**From:** Richard Temple  
**Sent:** 29 June 2017 17:12  
**To:** Nicola Spencer  
**Subject:** FW: Our Ref: 1194 re: 94 Harbour View Road, Pagham - Reference: P/23/15/HH

**From:** chris barrow [REDACTED]  
**Sent:** 28 June 2017 14:05  
**To:** Richard Temple  
**Subject:** Re: Our Ref: 1194 re: 94 Harbour View Road, Pagham - Reference: P/23/15/HH

Please find attached revised drawing 1194/4b giving the dimensions of the extension as built.

Drawing Number: 1194-4B

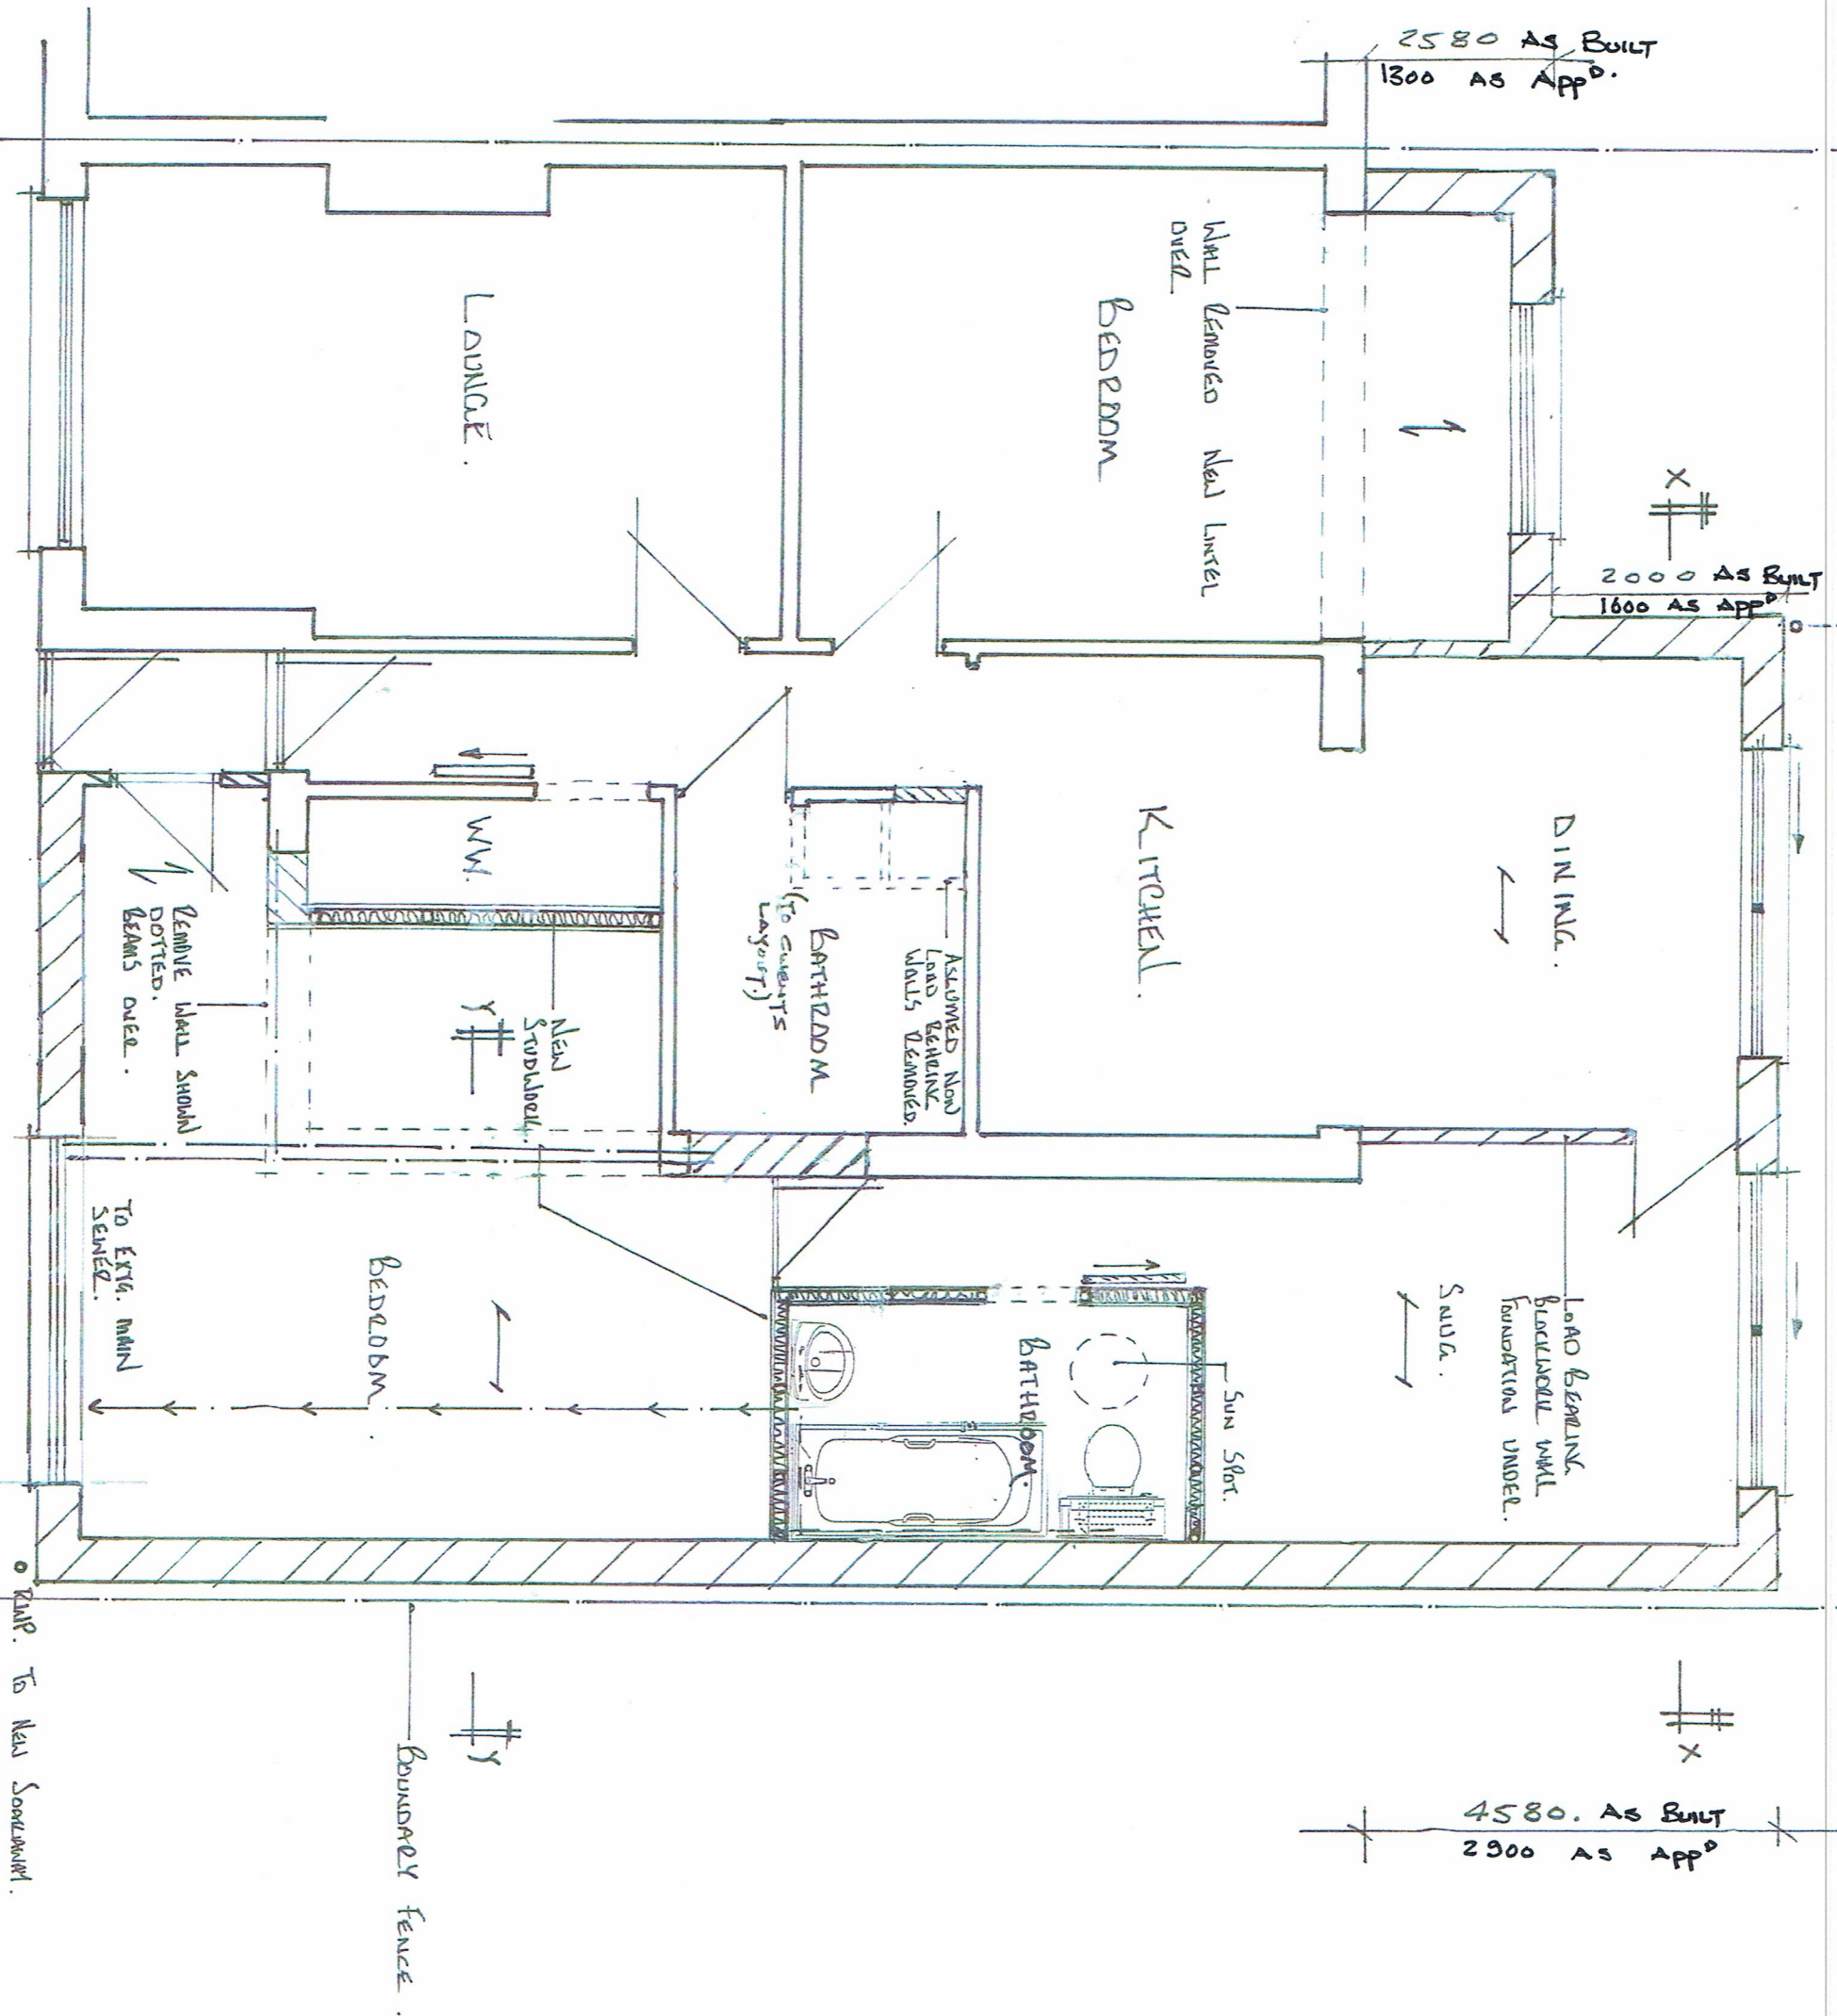
I can see what has happened. The scale on the drawing states 1:50 which scales to show the rear extension overall as 2.9m deep which is the same as originally approved.

Can the scale be amended to match the dimensions shown on the drawing?
